**Application by Highways England for an Order Granting Development  
Consent for the A63 Castle Street Improvement Scheme**

**PINS Reference TR010016**

**WRITTEN REPRESENTATION OF EPIC (NO.2) LIMITED**

**KINGSTON RETAIL PARK**

Drawing Title: **STREETS, RIGHTS OF WAY AND ACCESS PLANS REGULATIONS 5(2)(k) & 5(2)(o) OPTION A - SHEET 3 OF 6**

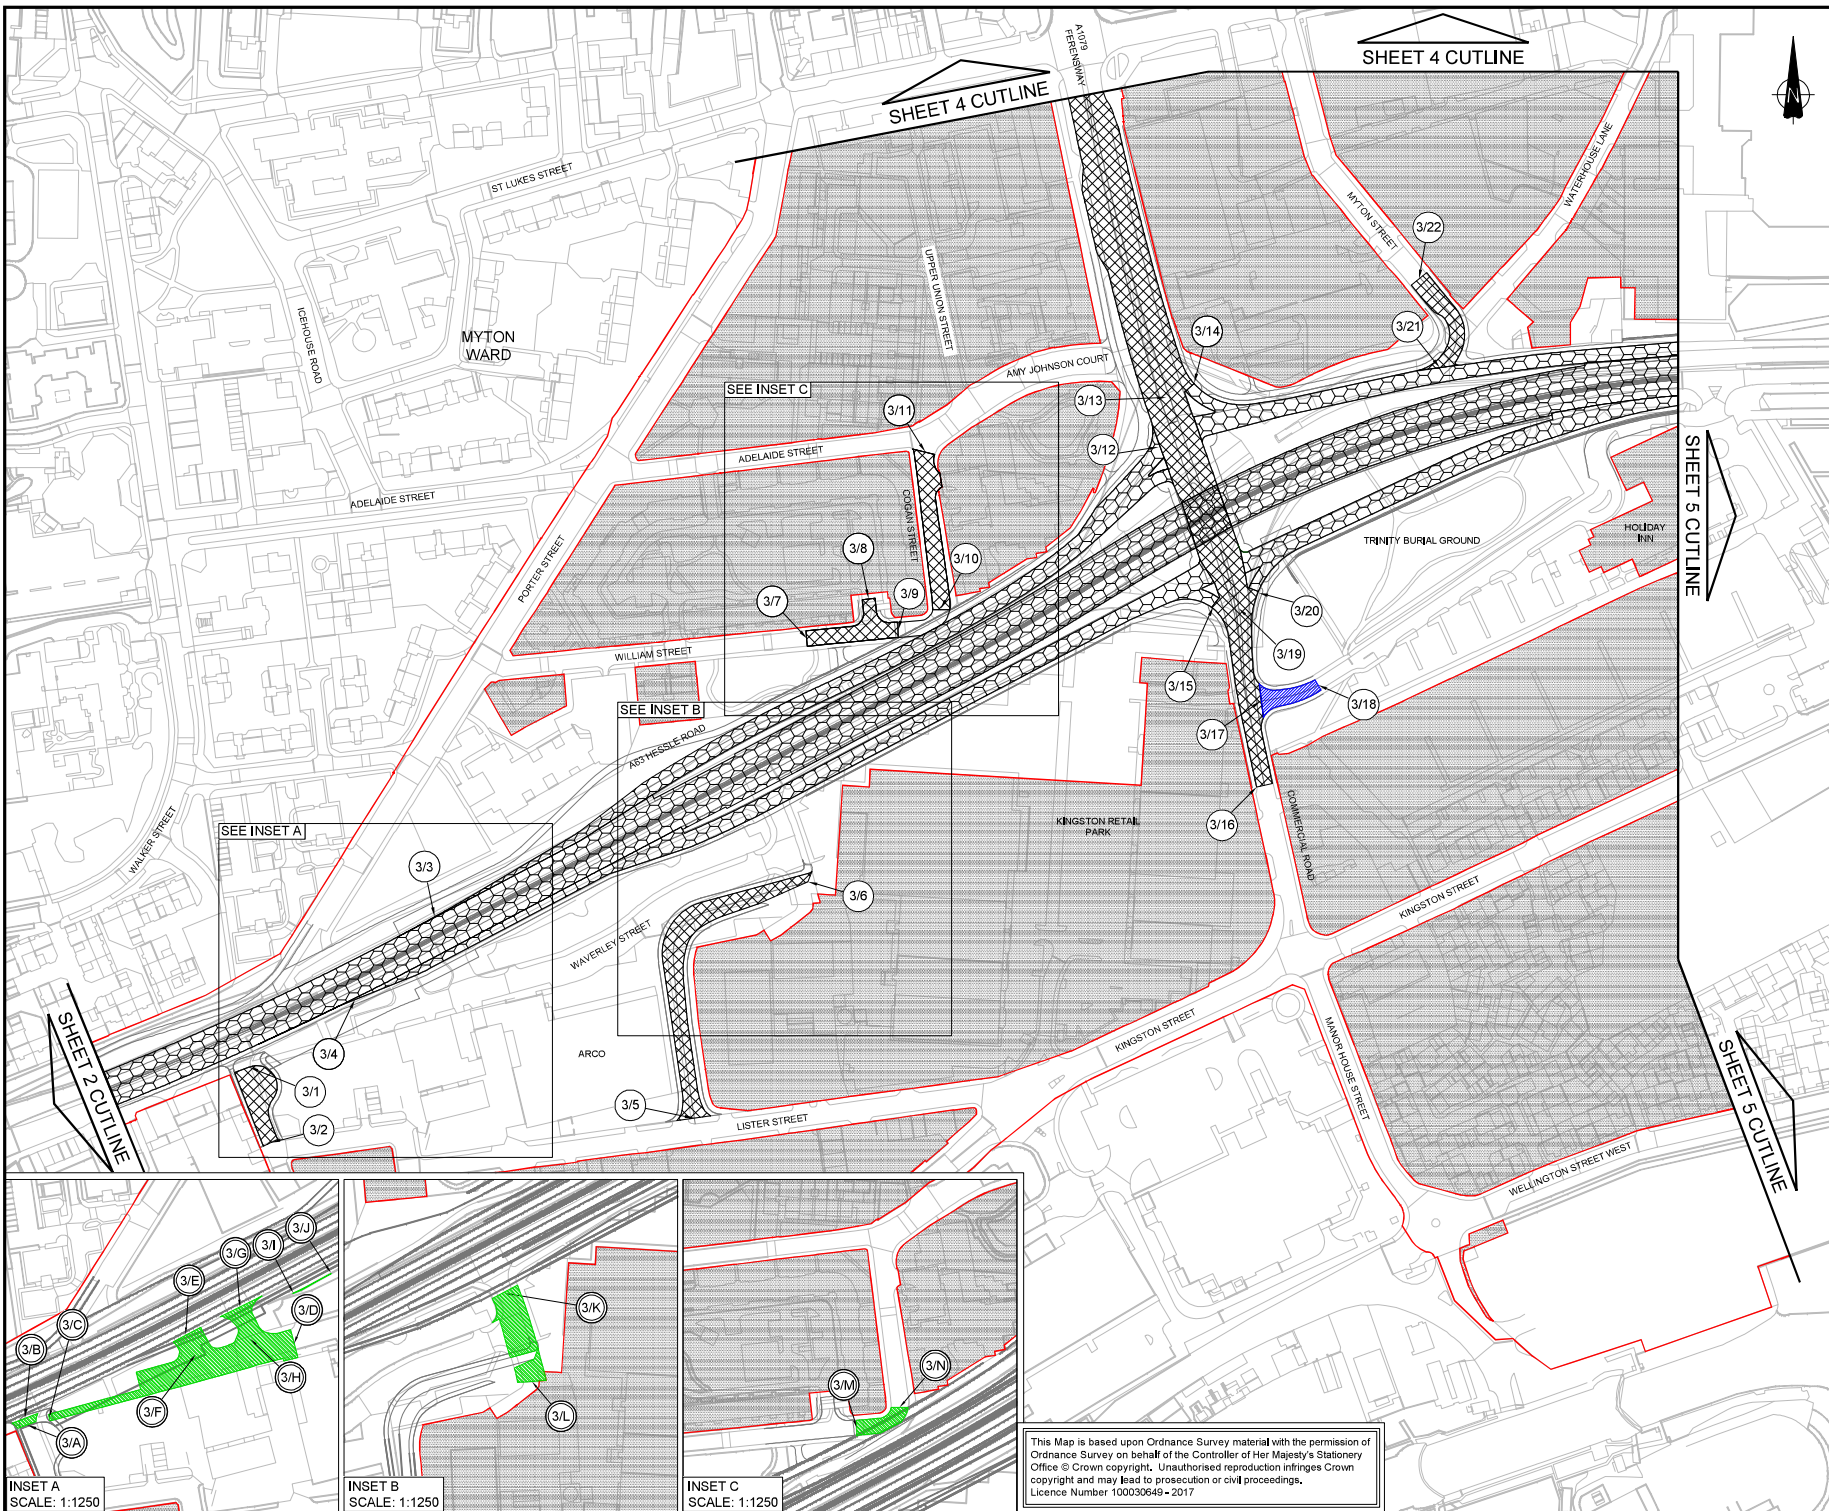
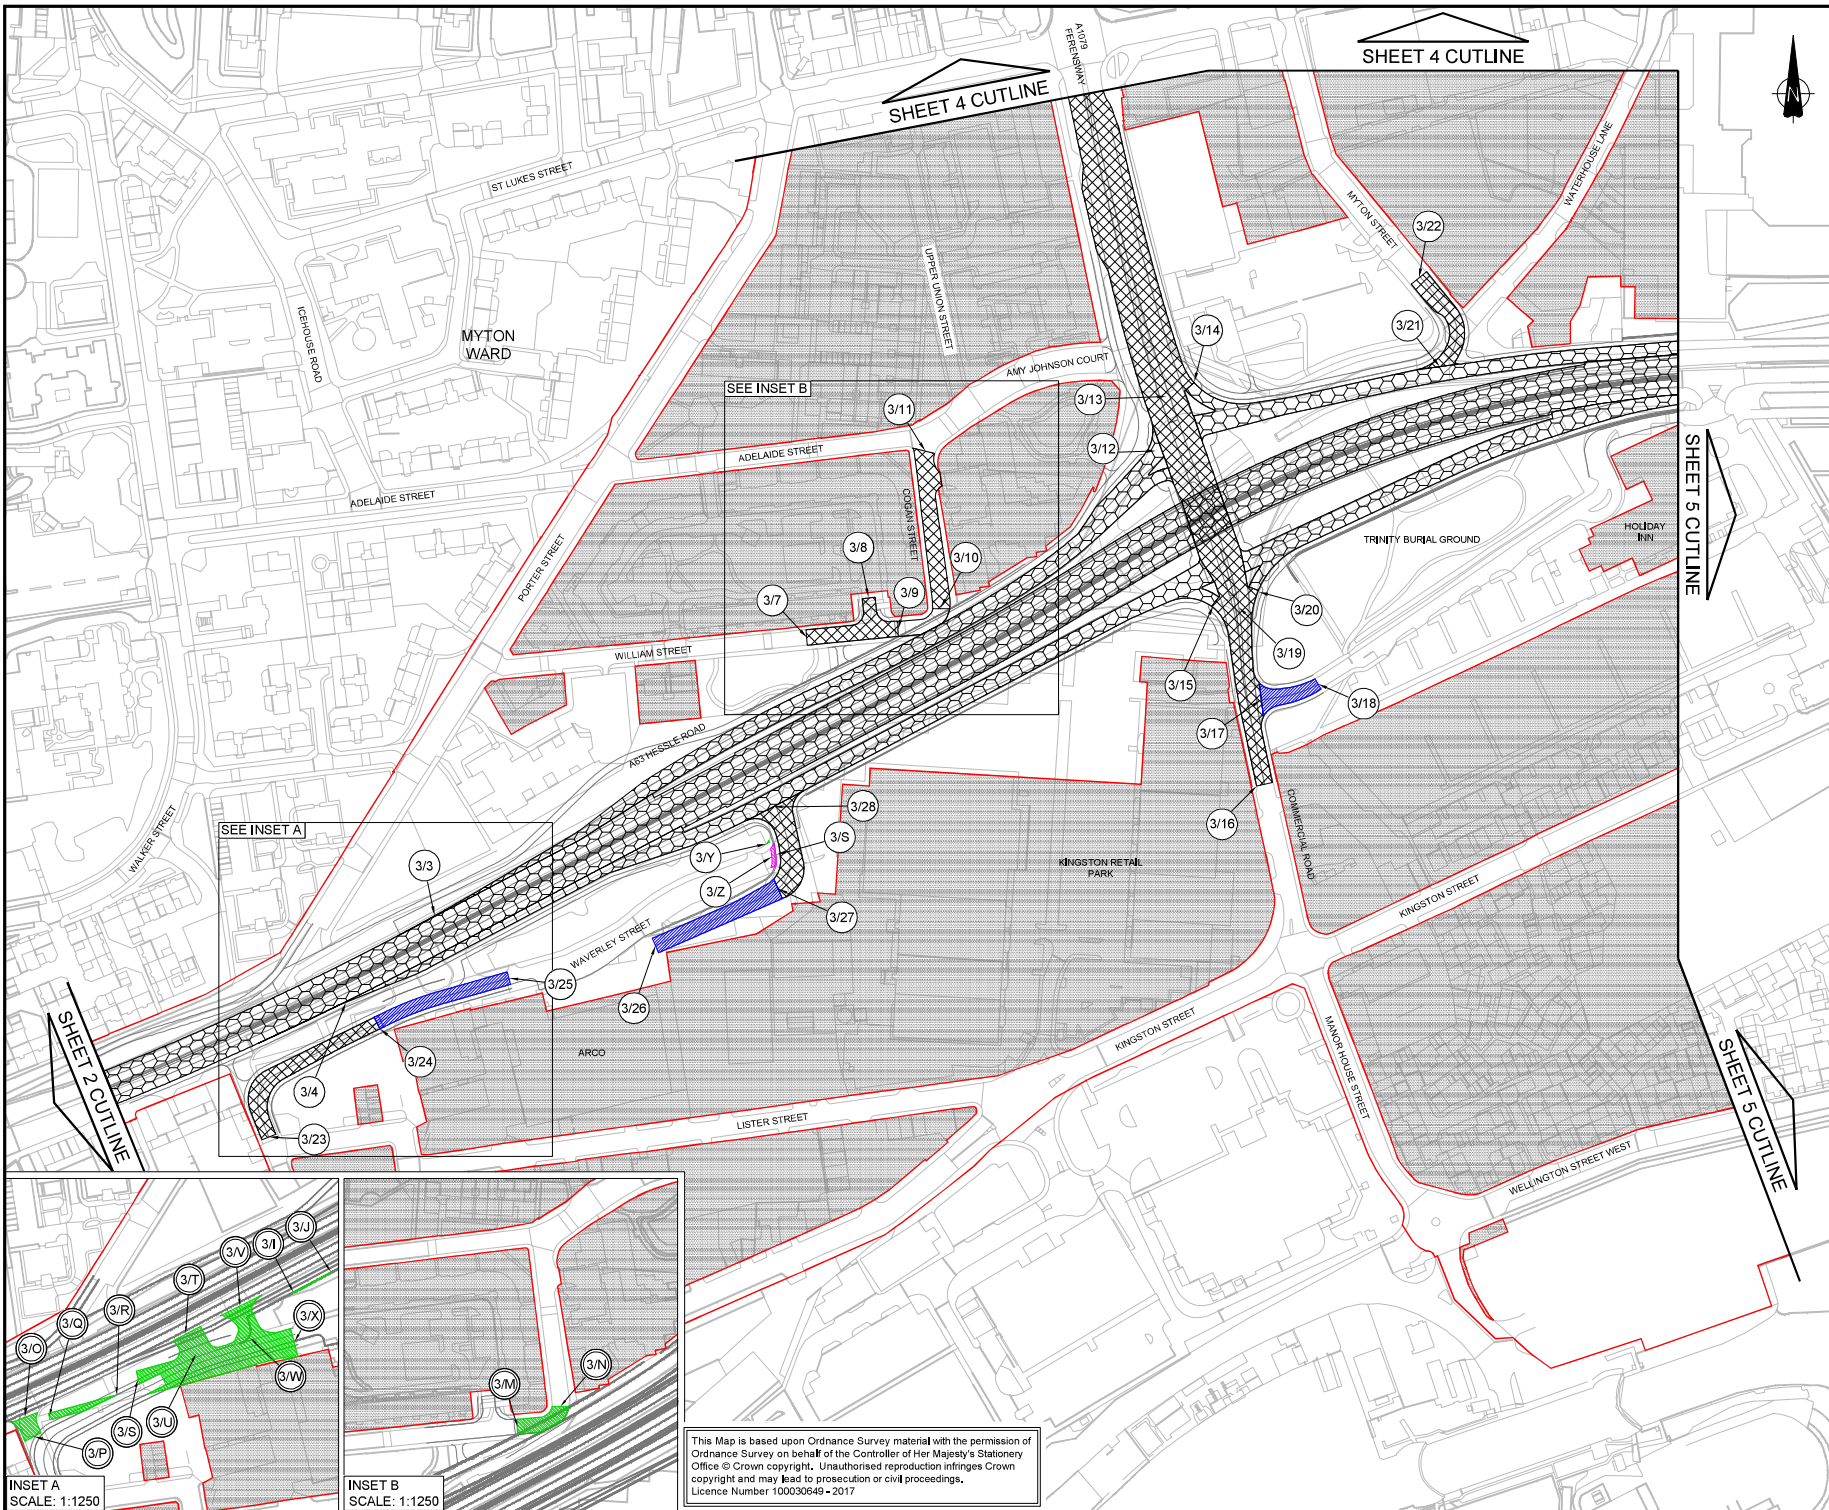
- 2.2.1 **Service Yard** – the proposed solution for service vehicles to access the western service yard does not allow a realistic route option for HGV traffic. Under Option A, unless amendments are made to the Streets, Rights of Way and Access Plans there will be a permanent loss of access to the western service yard from the highway;

- 3.10.1 Option A – point numbers 3/6, 3/L, 3/k and 3/15. This includes the stopping up of Spruce Road up to the boundary of the entrance to the service yard of Kingston Retail Park<sup>4</sup>. It does provide for a new road access from Lister Street but the plans do not show the new road being provided as highway to the boundary of Kingston Retail Park<sup>5</sup>. Unless it is amended, the right of access to the western service yard from the highway will be lost. This is critical and must be amended.

<sup>5</sup> From point 3/5 to point 3/6 on Streets, Rights of Way and Access Plans Sheet 3 and in accordance with Article 13 and Schedule 4, Part 1 of the proposed Order

Appendix G – Area of Stopping Up and Provision

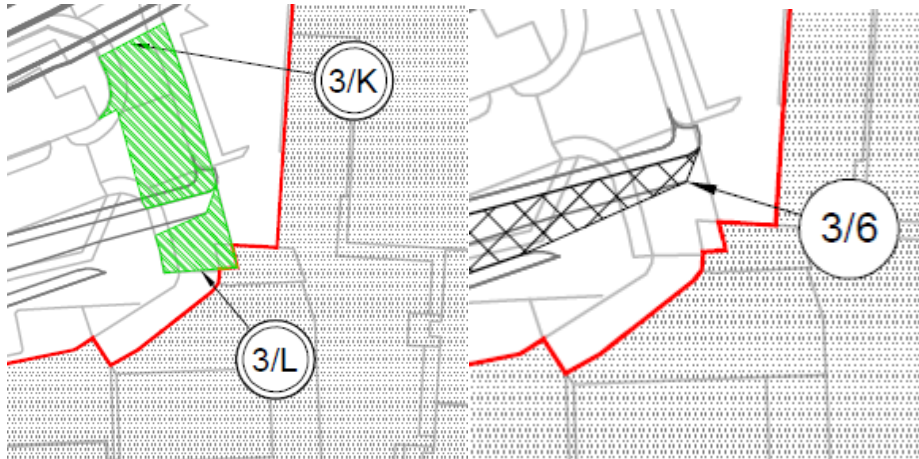
- 3.10.2 Option B – point numbers 3/28, 3/5 and 3/15
- 3.11 Plans of the plans relevant to Kingston Retail Park are at **Appendix F**. A document showing the area where the western service yard can no longer be accessed from the proposed new highway under Option A is attached at **Appendix G**.
